From: Chris Cruse <chris@cruseandassoc.com>
Sent: Monday, August 26, 2024 8:53 AM
To: Bradley Gasawski
Cc: Jamey Ayling; Zach Torrance-Smith; Chace Pedersen; Kim Black
Subject: Re: SP-24-00009 Black - Transmittal of Comments

Bradley - Thank for the chance to review the comments received for the Black Short Plat (SP-24-00009). Most are typical of similar applications but would like to clarify a couple issues.

BLACK SHORT PLAT

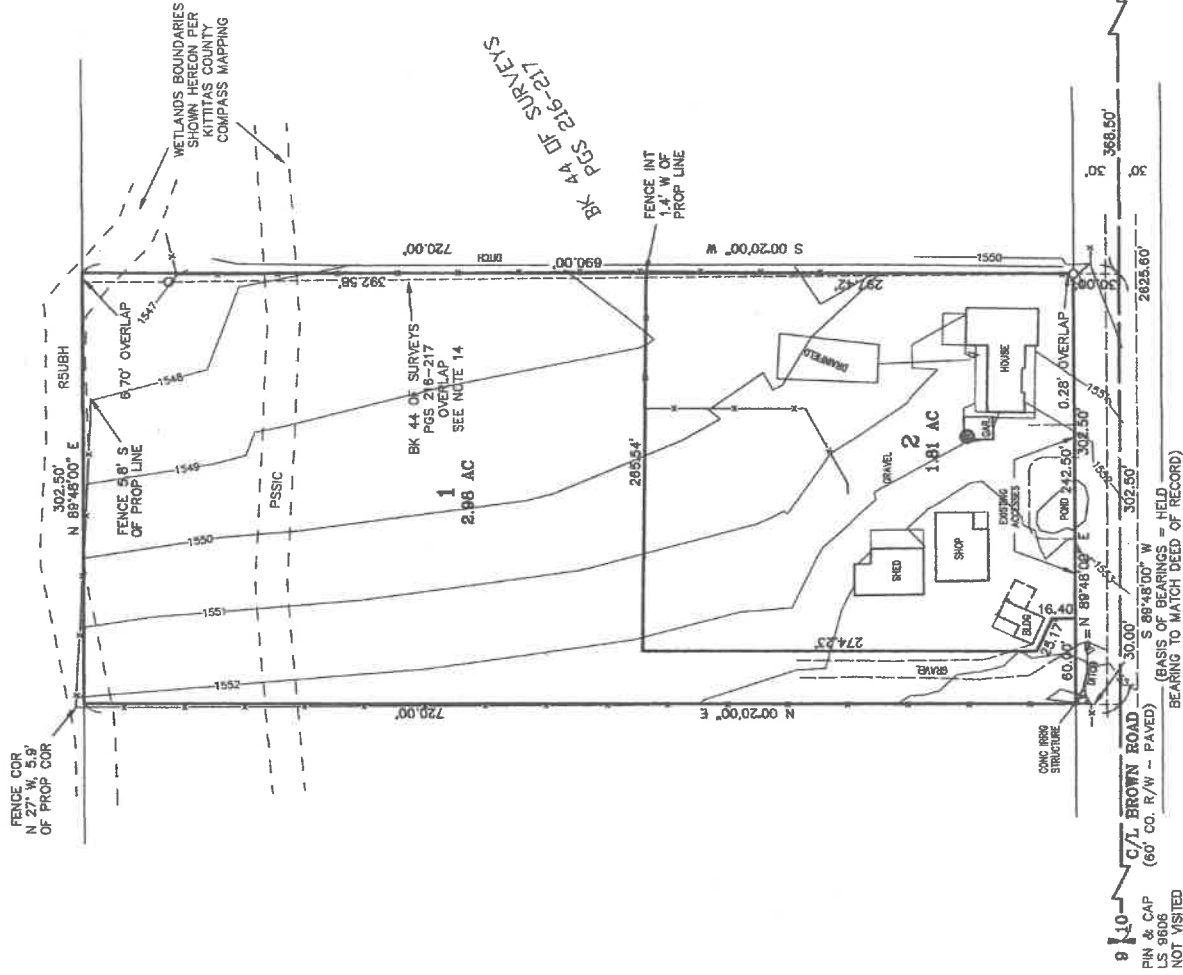
We will submit an updated application map to address the PW comments 1 and 3 in regards to the topographic elements and 5' setback label. PW comment 2 about KCC 17.29.090 is not relevant as KCC 16.12.040 that allows for this home to be split off contains a clause in code that allows for the new lots to have dimensions less than required by the AG-20 zoning.

WDFW suggesting the 100' set back from an irrigation ditch seems excessive. We agree to meet all setbacks and requirements required by county code when this lot is developed. Note 12 on the application map clearly states all future development will need to meet all codes and setbacks and should be sufficient to address the WDFW concerns.
